Byers Gill Solar
EN010139

8.32 Responses to the Examining Authority's Third Written Questions (ExQ3)

Deadline 7 - January 2025

Project Number 286386-00	Rev P01
Drawing Number BGS-ES11-0003

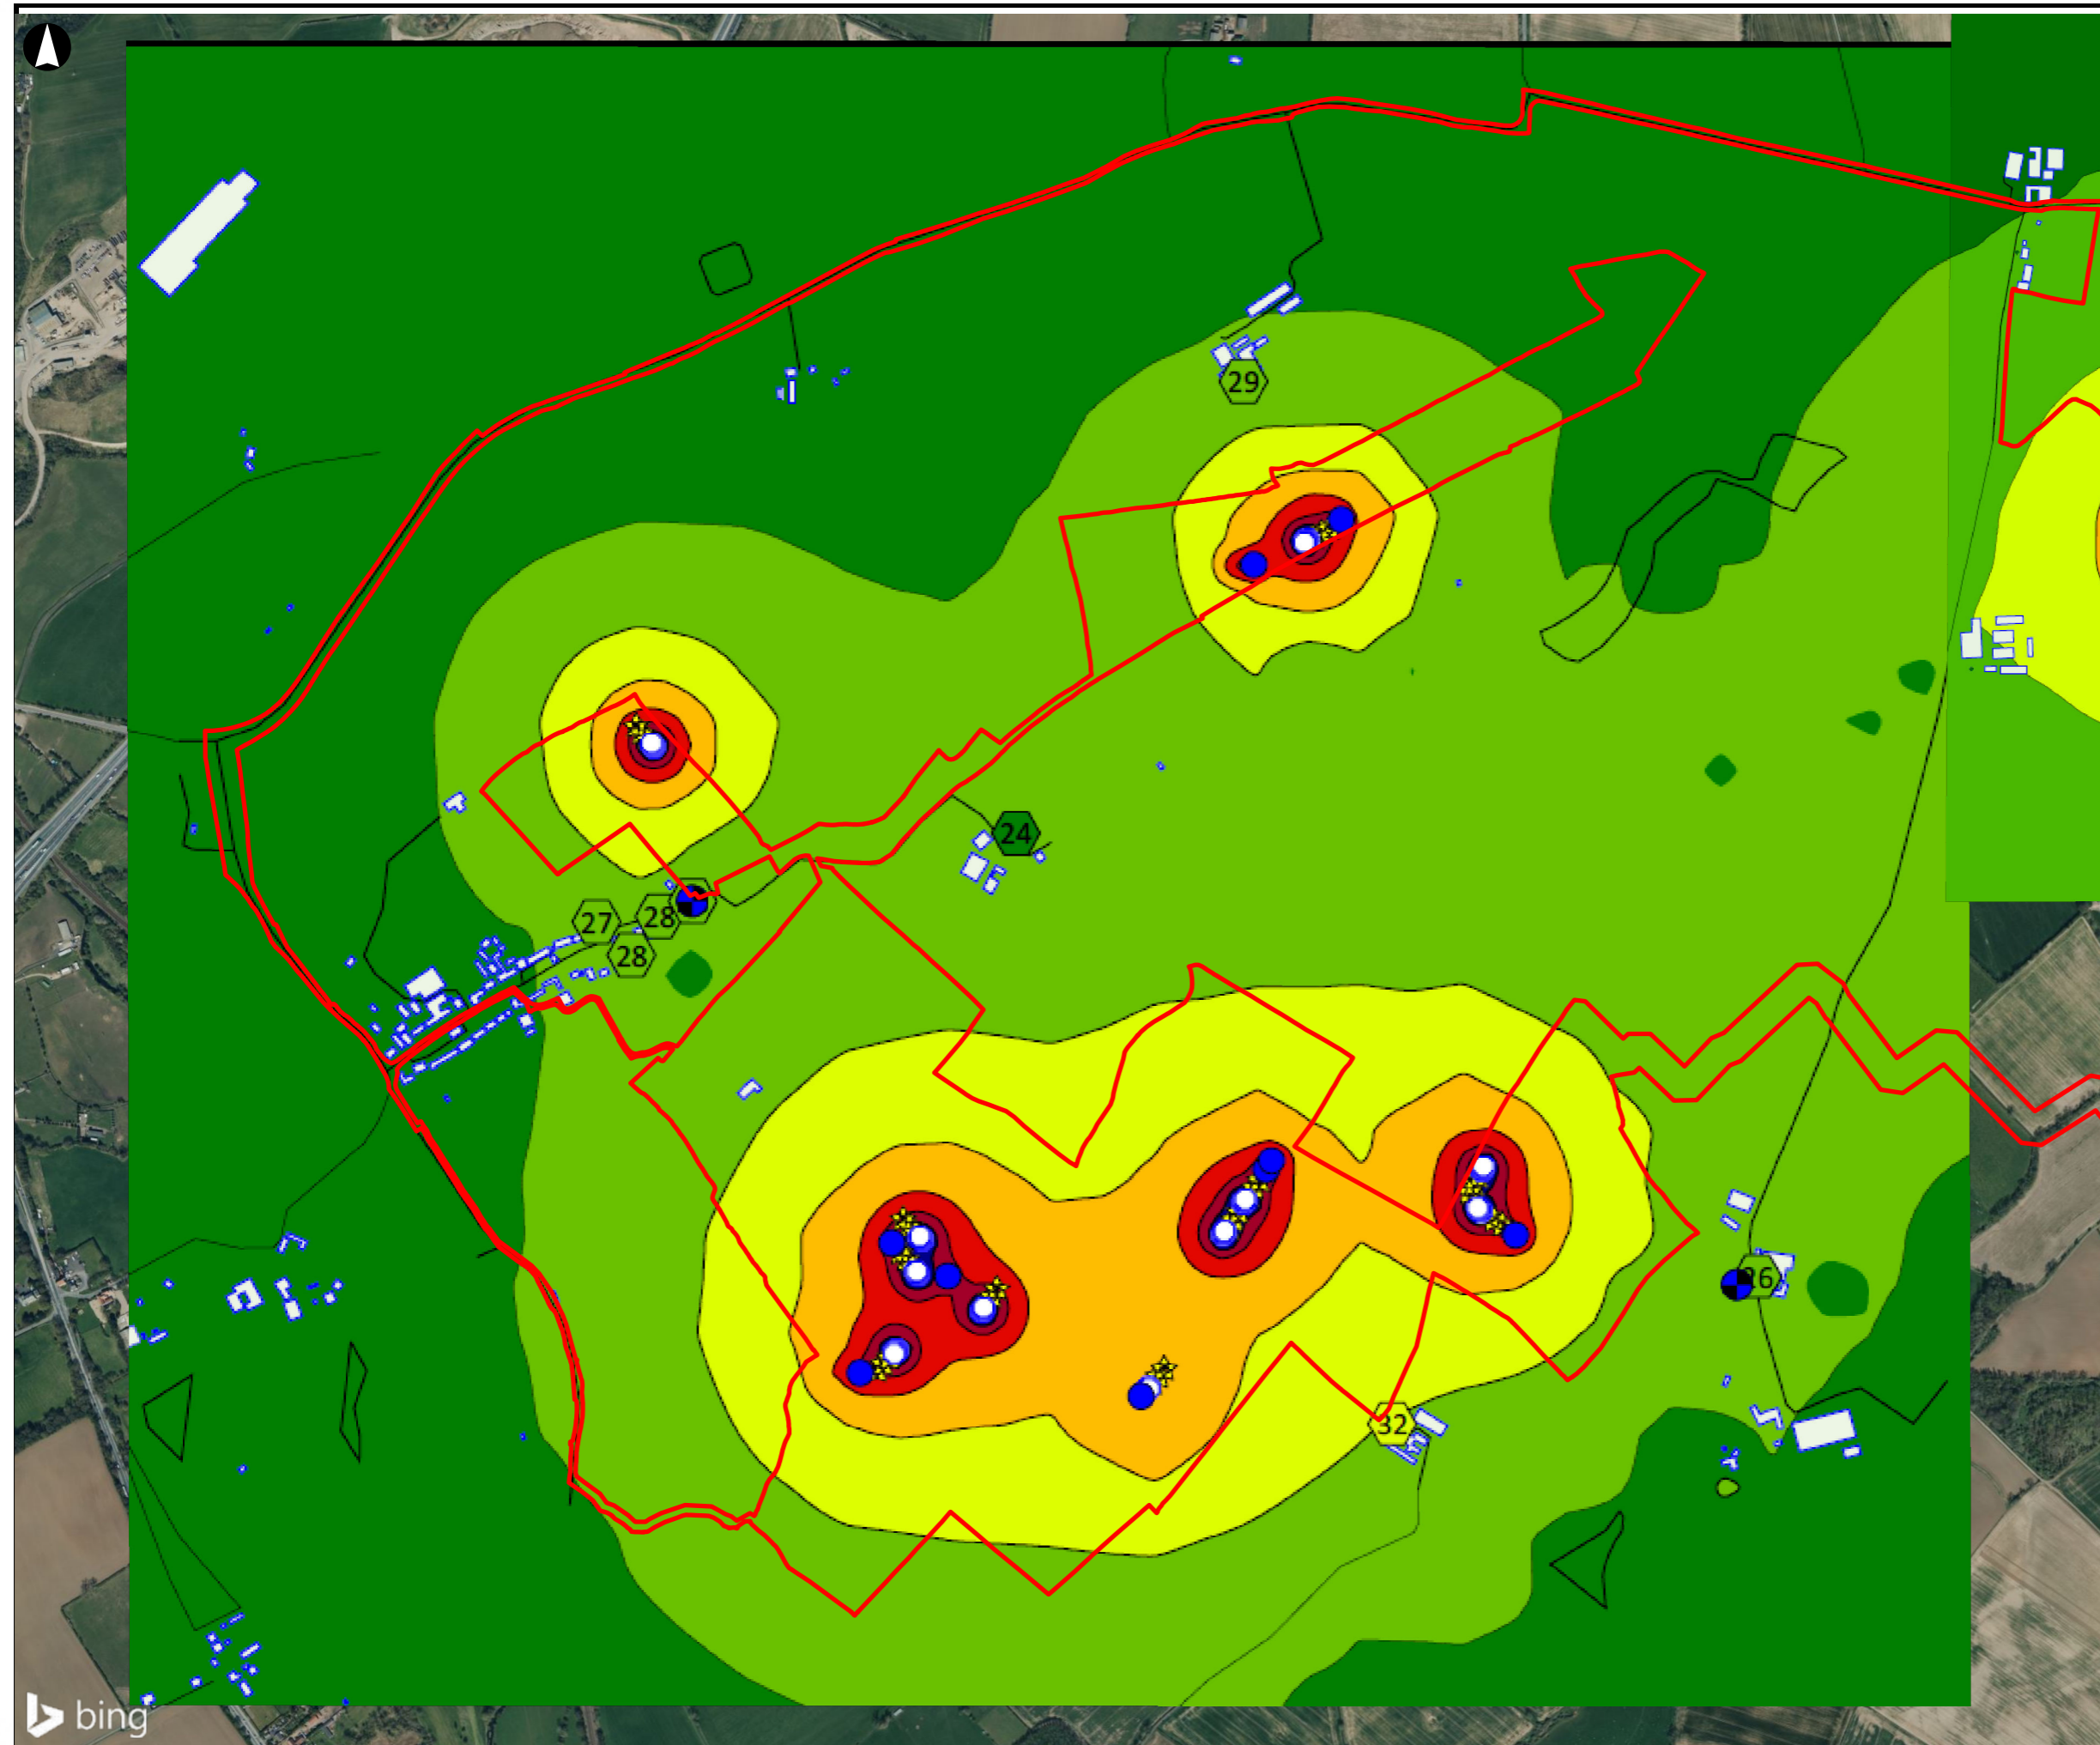
ExQ2	Question to	Question	Applicant's response
		to 'Carr House', which abuts its southeastern periphery, would the Applicant confirm if the noise impact of this building has been considered and if any of the buildings labelled ESR23 and ESR24 is indeed Carr House?	further confirms no significant effects would occur in relation to construction noise.
NV.3.5	Applicant	Referring also to the Applicant's SOCG with DBC [REP6-004], in view that DBC was also concerned with the non-inclusion of West House Farm and Downland Farm at the northern area of Panel F, would the Applicant confirm if the noise impact on these properties have been evaluated and if they are denoted as ESR41 and ESR42 on ES Figure 11.1 Sensitive Receptor Location Plan [REP4-014]?	The Applicant provided an update on this matter as raised in the DBC LIR [REP2-008] at Deadline 4, through its submission of amendments to the ES Appendix 14.1 BS4142 Assessment Calculations [REP4-005] and ES Figure 11.1 Sensitive Receptor Location Plan [REP4-014], which had accidentally omitted these ESRs. Downland Farm is depicted by ESRs 38 and 39, whilst West House Farm is ESR 42. The three ESRs have therefore been assessed within ES Chapter 11 Noise and Vibration [APP-034], which confirms that no significant operational noise effects would occur through the Proposed Development, whilst the Deadline 4 ES Addendum on Construction Noise [REP4-012] further confirms no significant effects would occur in relation to construction noise.

Drawing Title
**ES Figure 2.10
 Typical transformer, inverter and
 BESS arrangement**

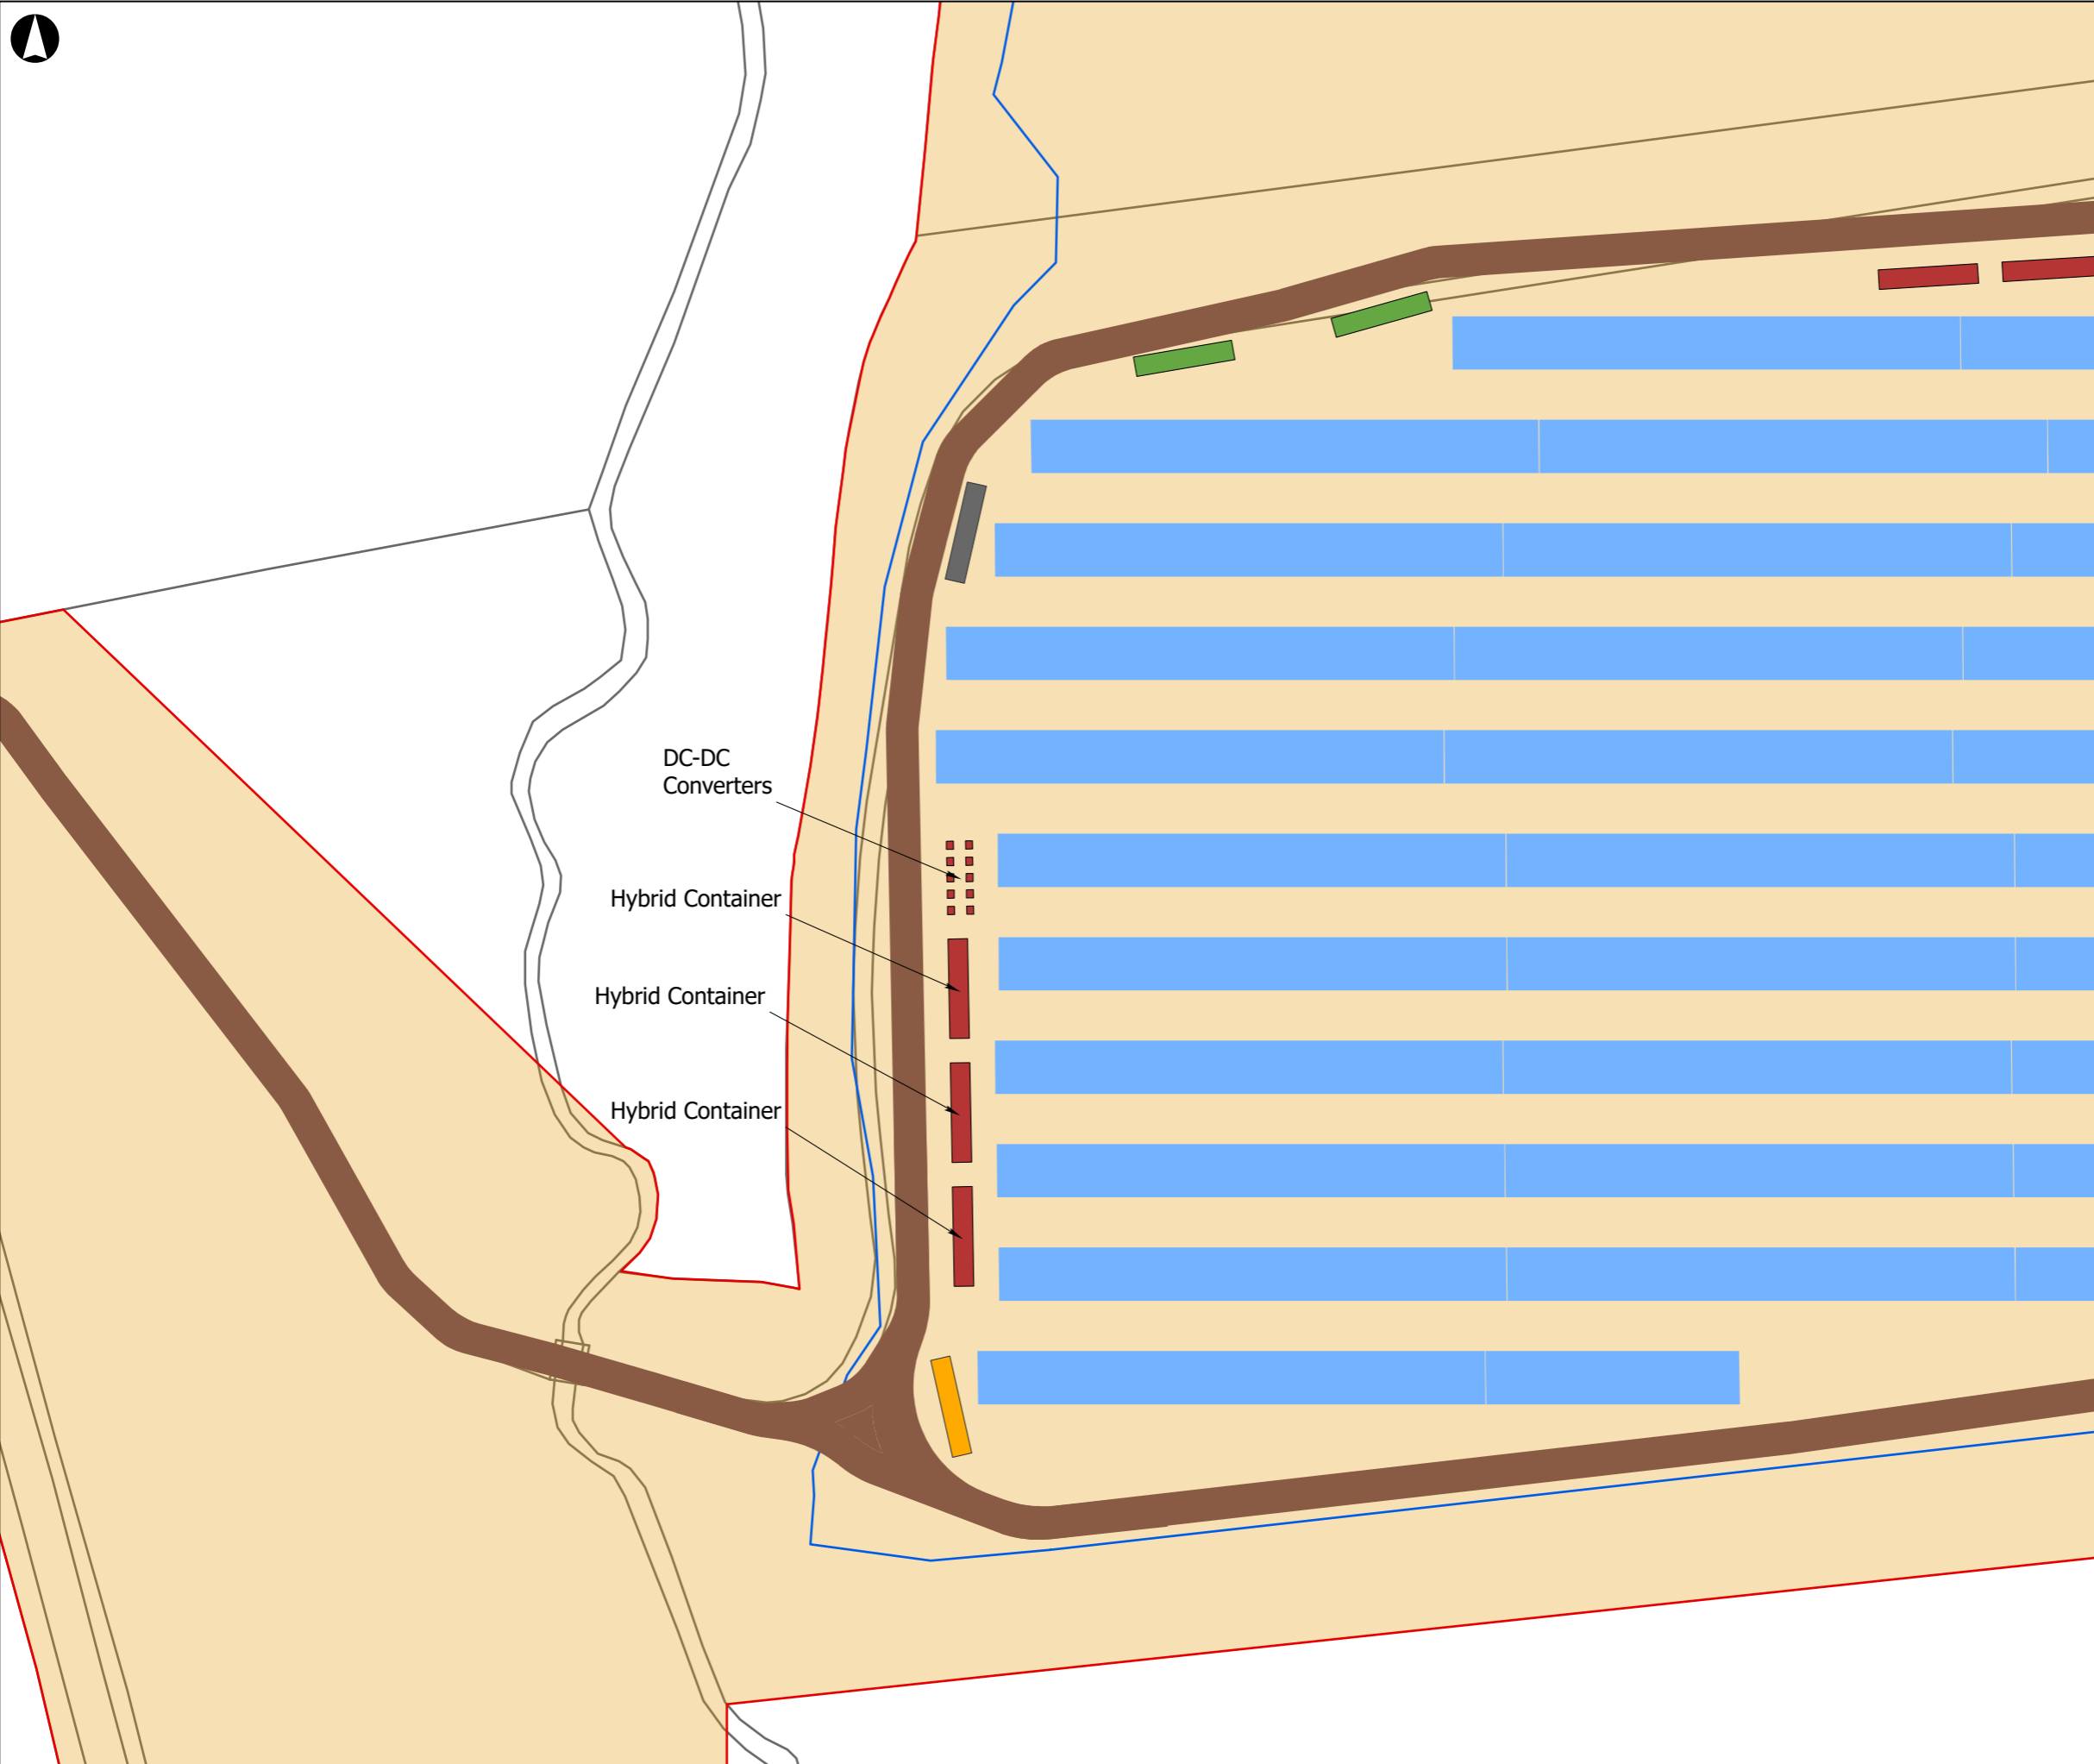
8. Design			
DES.3.1	Applicant	Paragraph 7.2 of Design Approach Document [REP5-025] states that the distribution of the onsite supporting equipment across the Order Limits which is shown on Plate 7-3 overleaf, has been designed in such a way that it is compliant with the industry safety requirements. Would the Applicant explain the type of industry standard that was applied to the distribution of these equipment?	<p>The location of the BESS is defined by constraints applied to the design such as distance from residential properties and avoidance of environmental features.</p> <p>The maximum allowable DC loss in the cables from the panels to the Inverter/BESS means we have to have the BESS/inverter within 500m of the panel. This is a standard that is required to make the design most efficient by reducing electrical losses and maximising the grid connection.</p> <p>Inverters have to be connected to a certain number of panels to work effectively at a minimum a 1:1 ratio DC to AC ratio, so an inverter is required at intervals equal to the amount generated by the solar panels to meet the capacity of the inverter.</p> <p>Inverters have to take a certain number of panels to work effectively at a minimum a 1:1 ratio DC to AC ratio.</p> <p>The design and manufacture of the BESS units themselves is governed by the relevant standards and regulations set out in section 6 of the Outline Battery Safety Management Plan [APP-117].</p>

DES.3.2	Applicant	Paragraph 7.2 of Design Approach Document [REP5-025] also mentions that the Battery Energy Storage System (BESS) has been placed at least 300m from residential properties in the majority of cases, to reduce the visual and noise impact of the infrastructure. Can the Applicant confirm the areas where the BESS would be sited less than 300m from residential properties and what extra mitigations have been proposed to minimise	There are two locations in which a residential property is less than 300m from BESS units. This is in Panel Area F, where the livery property on Cobby Castle Lane is approx. 175m from the western edge of BESS units and Downland Farm is approx.. 222m from the eastern edge of BESS units These are identified as Existing Sensitive Receptor (ESR) 40, and ESRs 38/39 on ES Figure 11.1 [REP4-014] respectively. The BESS is located less than 300m in this location due to constraints of other sensitive receptors such as the primary school and to minimise visibility from, and effects on, Mill Lane.

DES.3.3	Applicant	The 1st bullet point in paragraph 7.2,8 of Design Approach Document [REP5-025] states that	This is not an error. The BESS units are connected to the solar PV modules using DC-DC converters. The purpose of this is to stabilise the varying

ExQ2	Question to	Question	Applicant's response
		<p>the impact of such proximity of these areas or residential properties to the BESS?</p>	<p>As set out in ES Chapter 11 Noise and Vibration, no significant operational noise effects would occur through the Proposed Development at these ESRs. As a result of this, no further noise mitigation is proposed for operational noise effects.</p> <p>The Deadline 4 ES Addendum on Construction Noise [REP4-012] provides a more granular assessment of construction noise in response to concerns raised in submissions by Interested Parties, including Cobby Castle Livery. This identifies that PV module construction, assessed on an indicative worst-case, would result in a noise level below the 65dB noise level threshold and would result in a minor adverse effect which is not significant in EIA terms.</p> <p>Considered specifically as an equestrian receptor, it is however likely that ESR40 would experience a significance of effect equal to 'Moderate' for a period of time less than a month. Control measures under commitment NV4-CEMP secured via the outline CEMP at Deadline 5 [REP5-012/13], require that engagement with the livery businesses would be undertaken to manage and minimise such temporary effects, such as by relocating horses to different fields when construction works are ongoing.</p> <p>In terms of effects on residential visual amenity, the BESS would be of the same maximum height as the solar panels and no different or additional mitigation is required for the BESS compared to solar panels.</p> <p>As shown on Sheet 10 and 11 of the Environmental Masterplans [REP6b-008], a community orchard and hedgerow planting would be located between the property at Cobby Castle and the BESS, providing screening. No additional or 'extra' mitigation is considered necessary in this location relating specifically to the distance of the BESS.</p> <p>At Downland Farm to the east, the Masterplans [REP6b-008, Sheet 10) show that visual effects are mitigated through set-backs of the panels from the property and hedgerow infill to provide screening. No additional or 'extra' mitigation is considered necessary in this location relating specifically to the distance of the BESS.</p>

ExQ2	Question to	Question	Applicant's response
		<p>inverters convert the DC generated by the solar PV modules into alternating current (AC) that can be exported to the national grid. Would the Applicant confirm if the DC-DC converter mentioned in the 3rd bullet point of the same paragraph and annotated on Plate 7-3 should have read DC-AC converter?</p>	<p>voltage generated by the solar PV modules in DC current to ensure the batteries are charged in DC current with an even flow of electricity. The solar PV modules and / or BESS can then discharge into the AC/DC inverter for transmission to the on-site substation and National Grid. An illustration of this is provided below:</p> 
<p>9. Health and Air Quality</p>			
<p>HAQ.3.1</p>	<p>Applicant</p>	<p>At OFHs concerns have been raised by several different IPs regarding the impact that the Proposed Development is likely to have on their general well-being, particularly in relation to stress levels linked to the Proposed Development. Can the Applicant please confirm if these have been considered and how the Applicant has mitigated against these?</p>	<p>The potential effects on health and well-being were considered through the scoping process with PINS, through the Scoping Opinion [APP-121] agreeing that a separate chapter on Human Health is not required and can be scoped out. This opinion was on the basis that potential health impacts are addressed in the individual topic chapters of relevance.</p> <p>It is the Applicant's opinion that potential effects of the Proposed Development which could influence health and well-being have been considered and presented through the relevant topic chapters of the Environmental Statement (ES). This includes Landscape and Visual [AS-028/29] and Land Use and Socioeconomics [APP-032], whilst management plans are secured via the DCO which secure the implementation of</p>
